Ribble Valley Borough Council  
Church Walk,  
Clitheroe,  
BB7 2RA

Phone: 0300 123 6780  
Email: [lhscustomerservice@lancashire.gov.uk](mailto:lhscustomerservice@lancashire.gov.uk)  
Your ref:  
Our ref: LHS/CS/3/2016/0170  
Date: 24<sup>th</sup> March 2016

<b>Proposal:</b>	Proposed additional operational car parking spaces, internal (within site). Amendment to access/egress arrangement to existing access to/from Pimlico Link Road.
<b>Location:</b>	Clitheroe Community Hospital Chatburn Road Clitheroe BB7 4JX
<b>Grid Ref:</b>	375444 - 443028

| drawing | Proposed Site Plan |

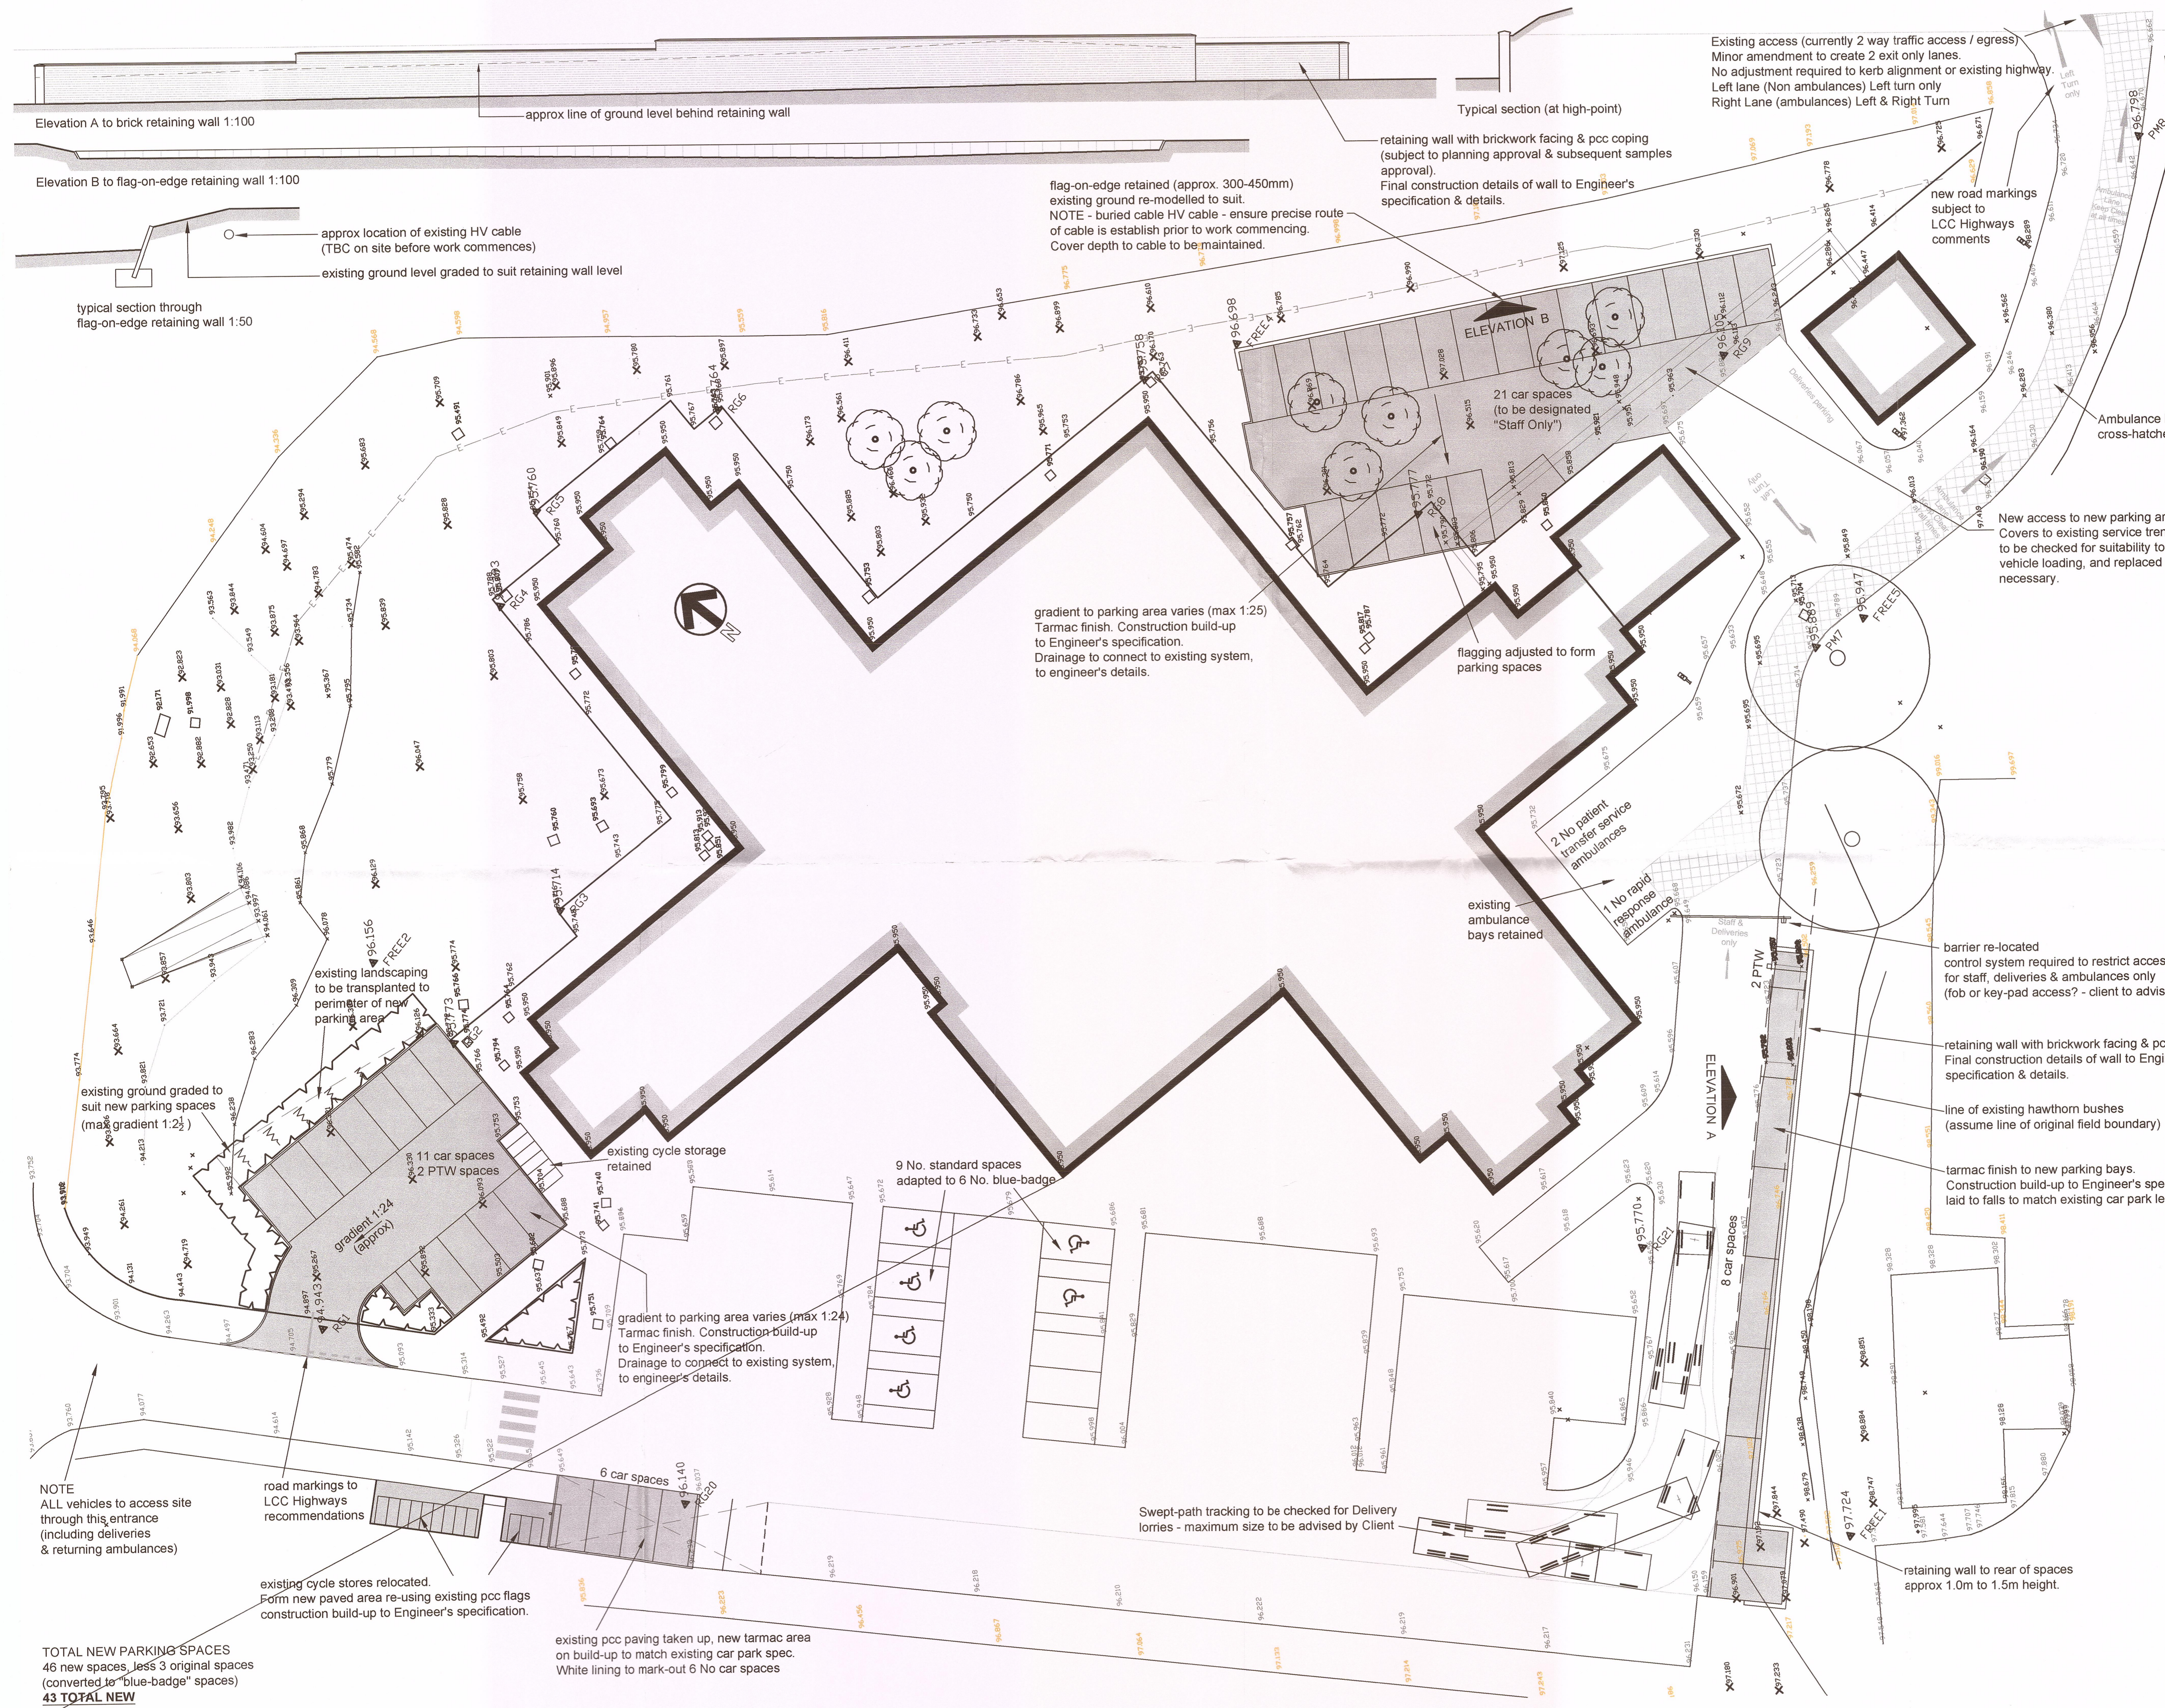
The proposed one-way system is positively encouraged by the Highway Development Control Section, providing adequate lining, signing and enforcement is provided in the interest of highway safety and abuse of the one-way system. The Highway Development Control Section recommends the applicant provides one-way gator teeth at the northern entrance to the site to ensure the one-way system is not abused. The applicant is also to provide details of the gator teeth, signing and lining of the one-way system, these recommendations can be conditioned.

1. A scheme for the one-way system to be approved by the Local Planning Authority and the one-way system and associated physical restraints, signing and lining to be provided in accordance with the approved plan, before the use of the premises hereby permitted becomes operative and permanently maintained thereafter. Reason: To allow for the effective use of the one-way system.
